RFI

RFI #: 125
 Date: 5/21/2012
 Job: EB-02 Keller Springs Lofts
 Phone: 877-777-5115

CC:
 Subject: A1 and A1-HC Unit Questions

Drawing: A2.2 & A2.2HC
 Cost Impact: None

P-2.11

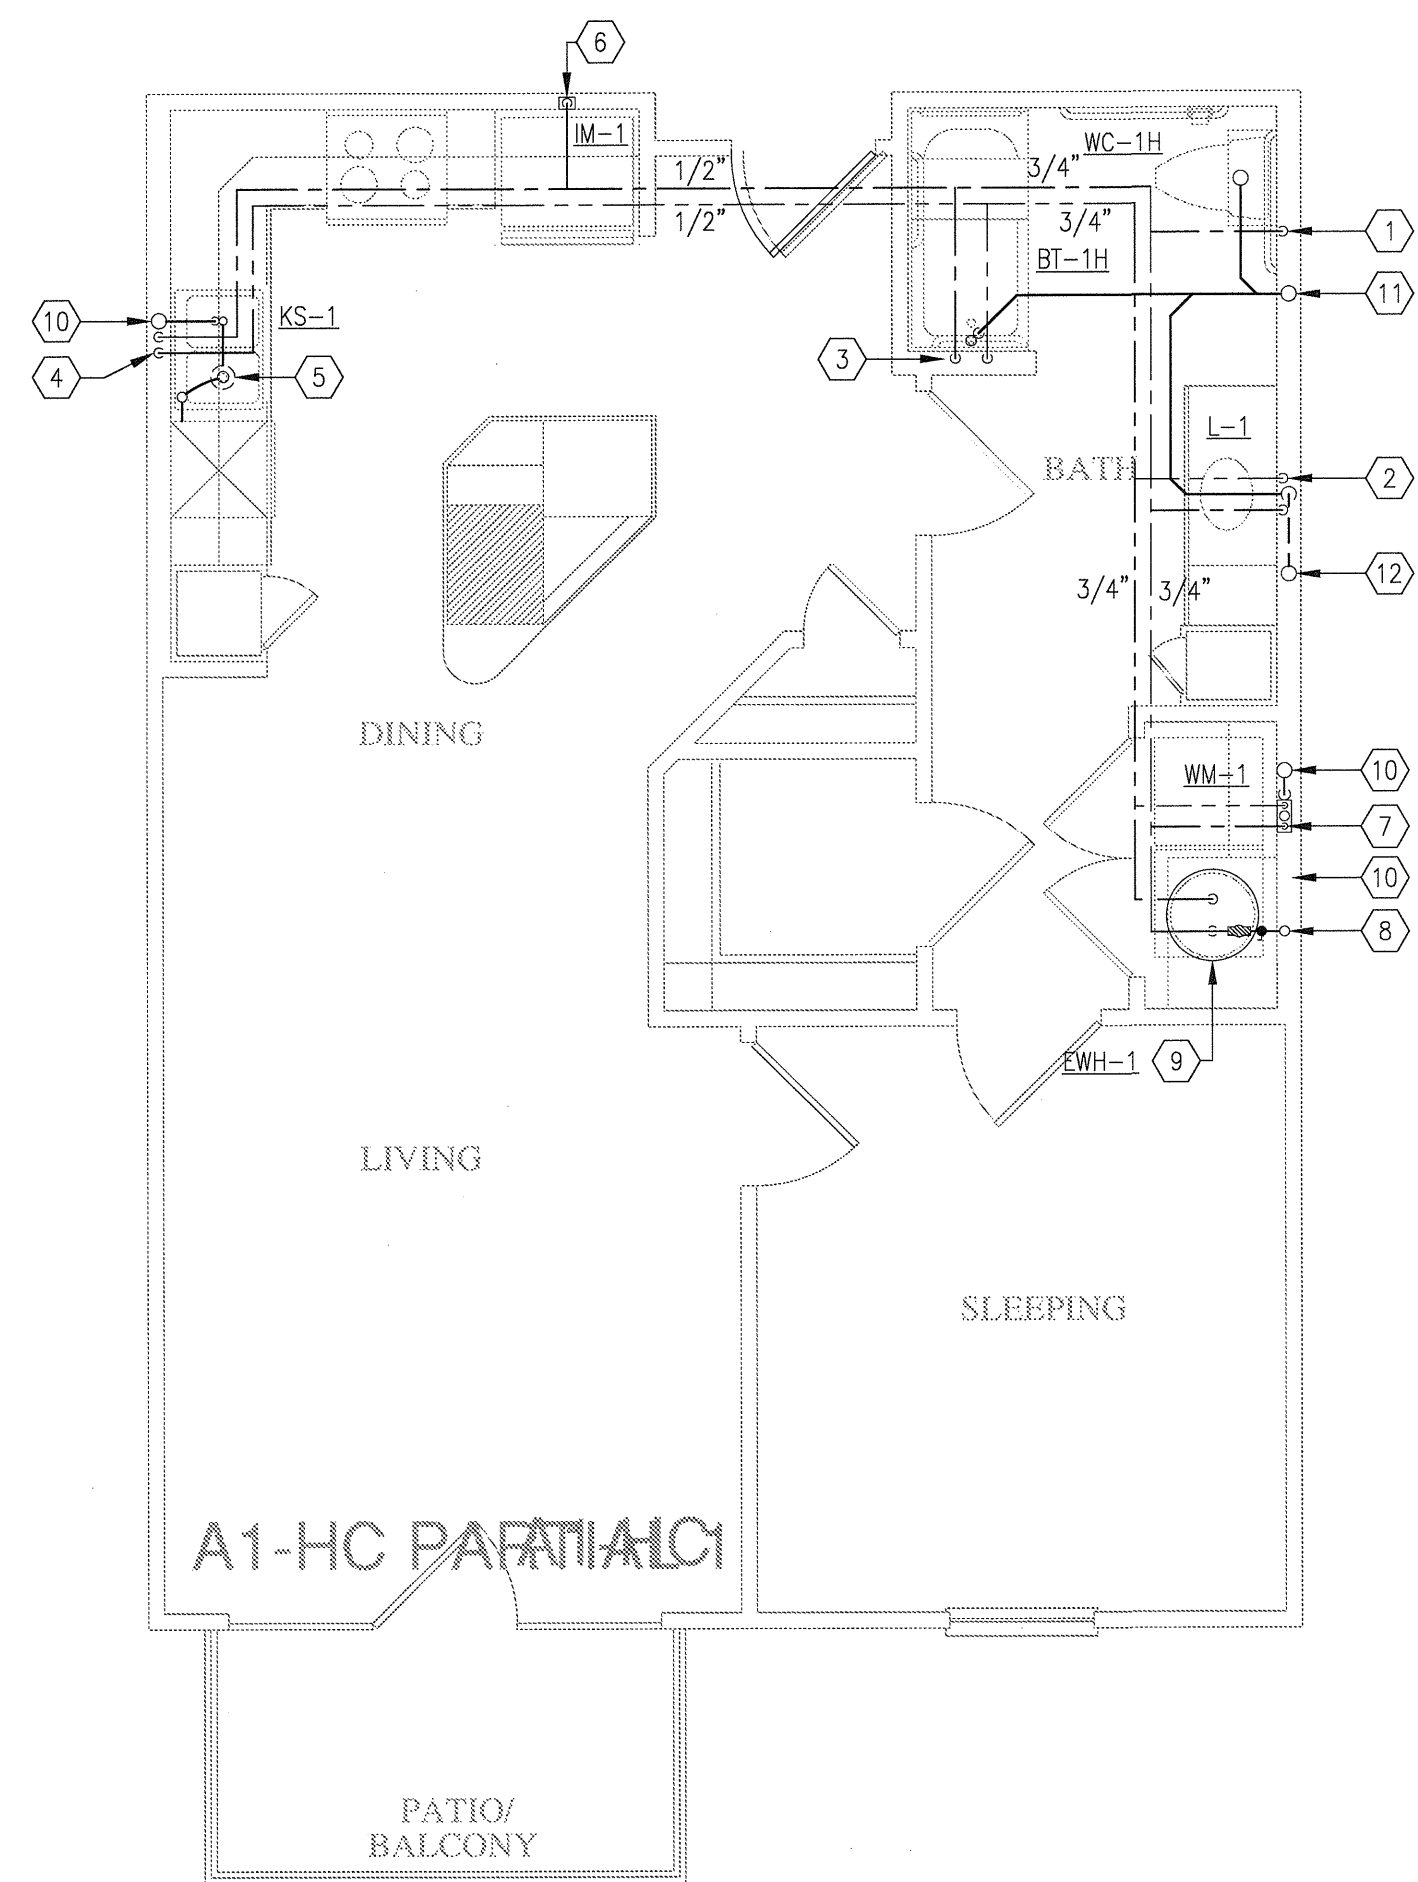
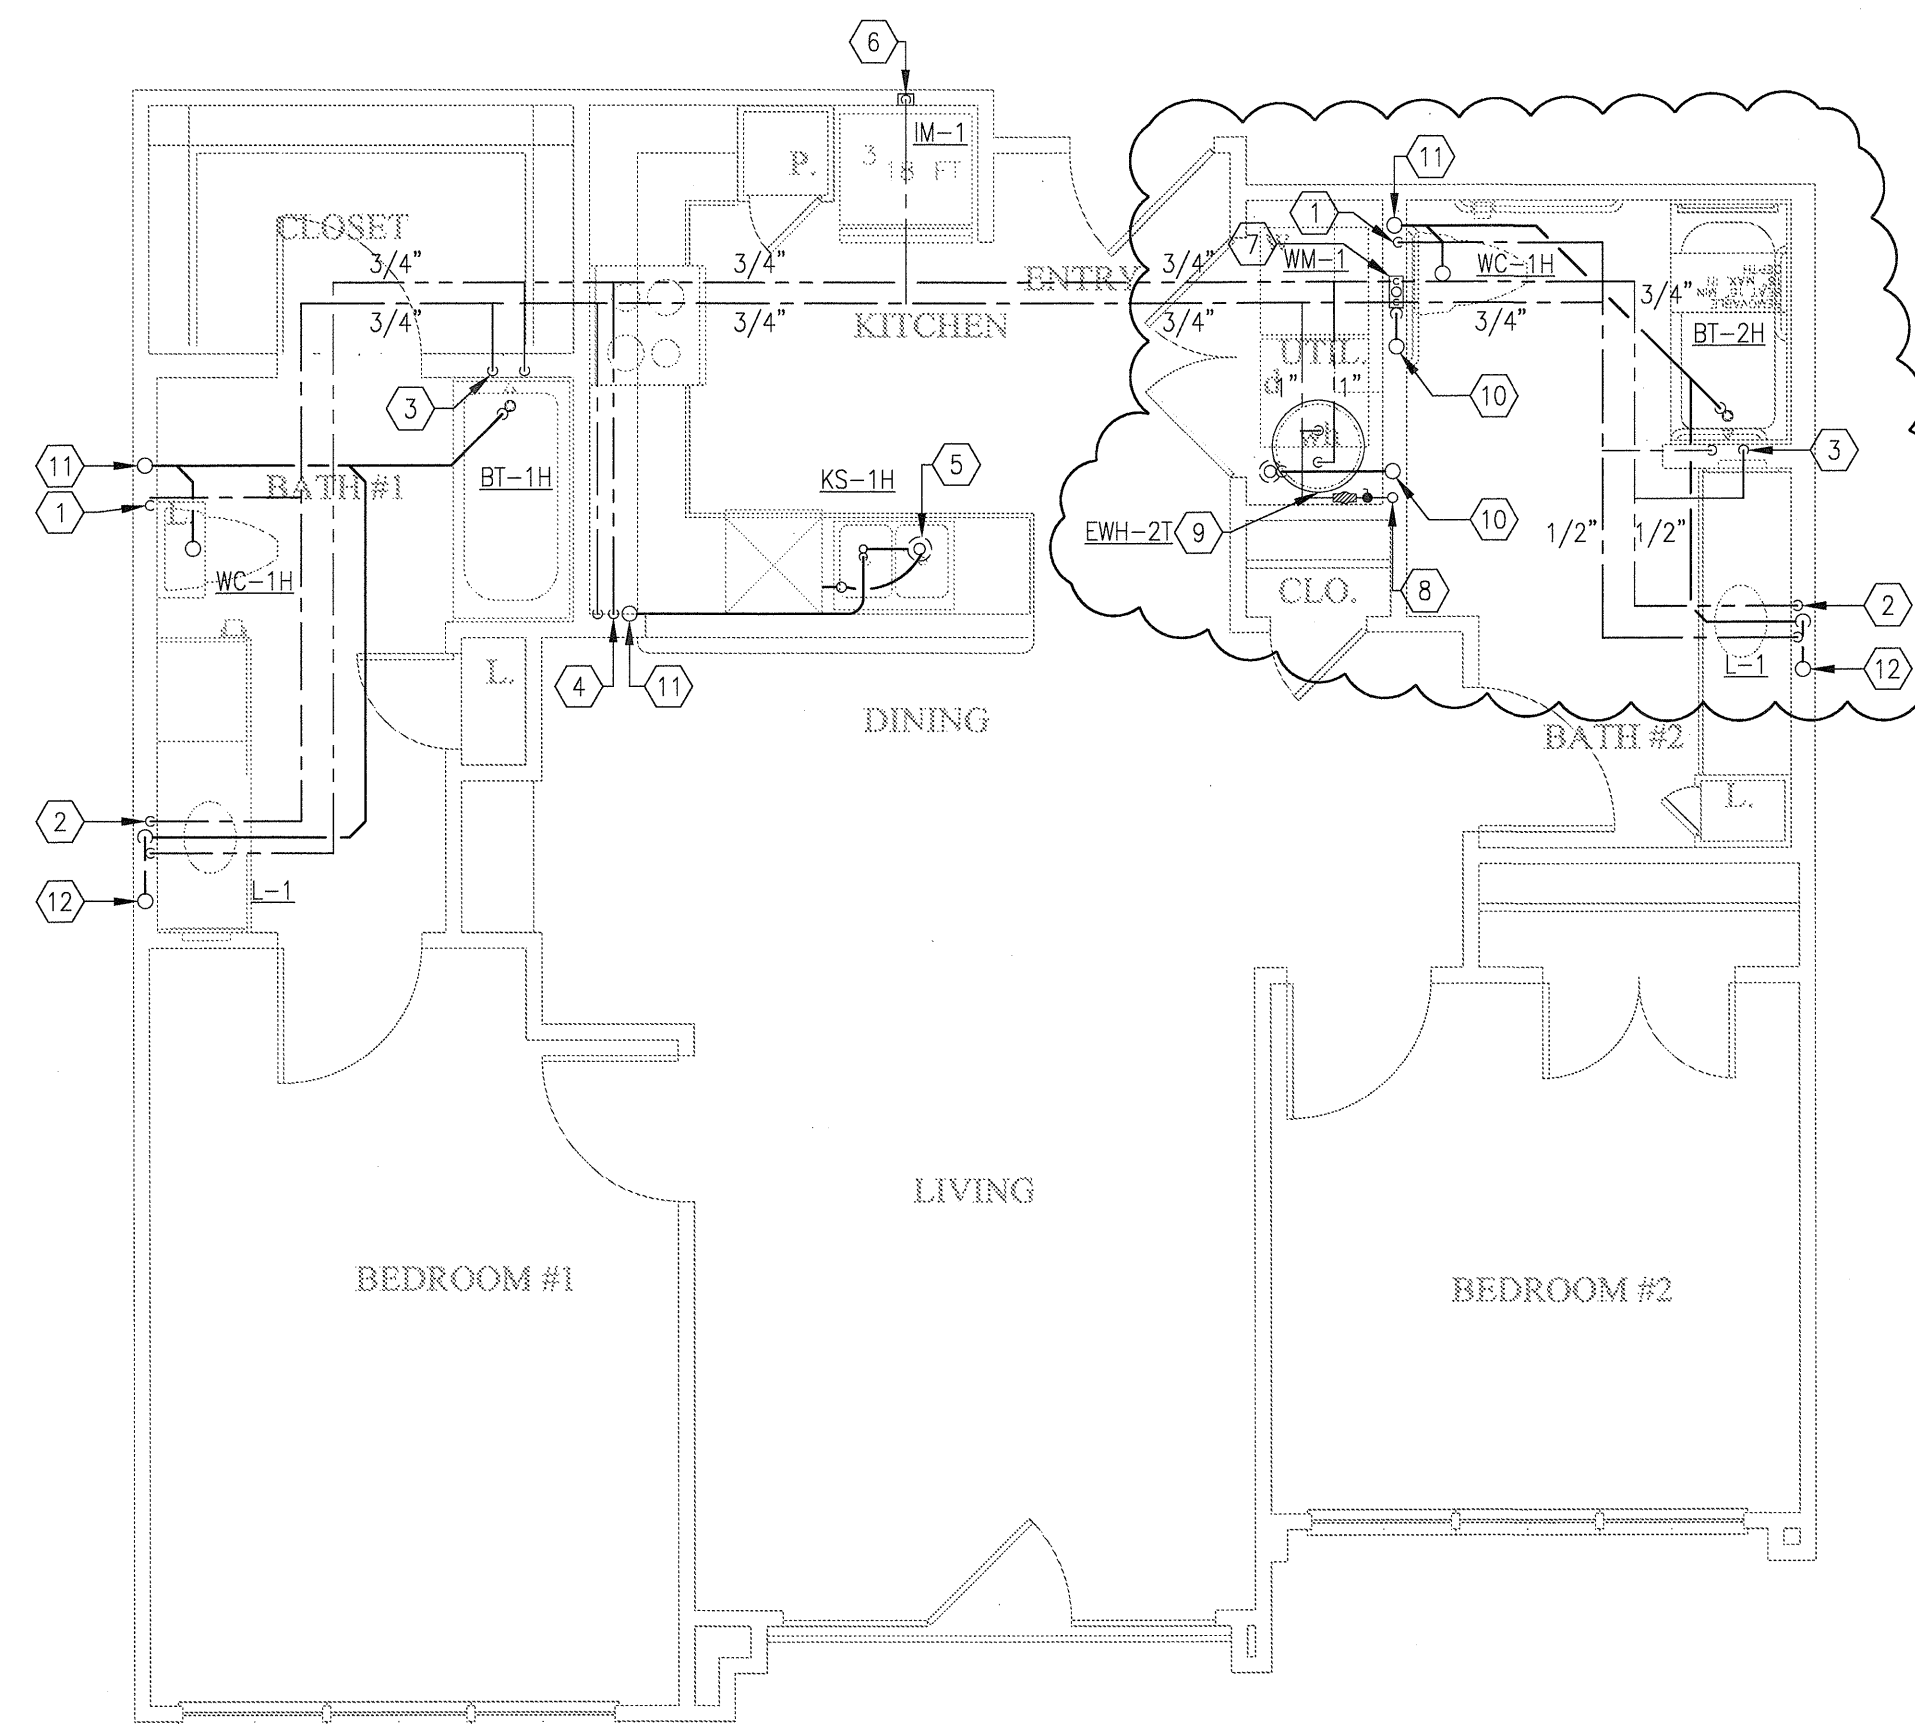
Request: Date Required: 5/29/2012
 A1 Unit - Please provide length of wall dimension for wall that separates vanity and toilet.
 A1HC Unit - Please provide door number for bathroom door from the kitchen area. Also provide dimensions for where the door sits.

Response: The wall in the A1 unit is 2'-1".
 The door tag in A1HC is 10.
 Off the plumbing wall where the tub is, the wall is 4" for the door frame, the door is 3'-0", then there is 2'-0" till the wall where the closet door is.
 The dimension text that is on top of the door tag says 5'-4".
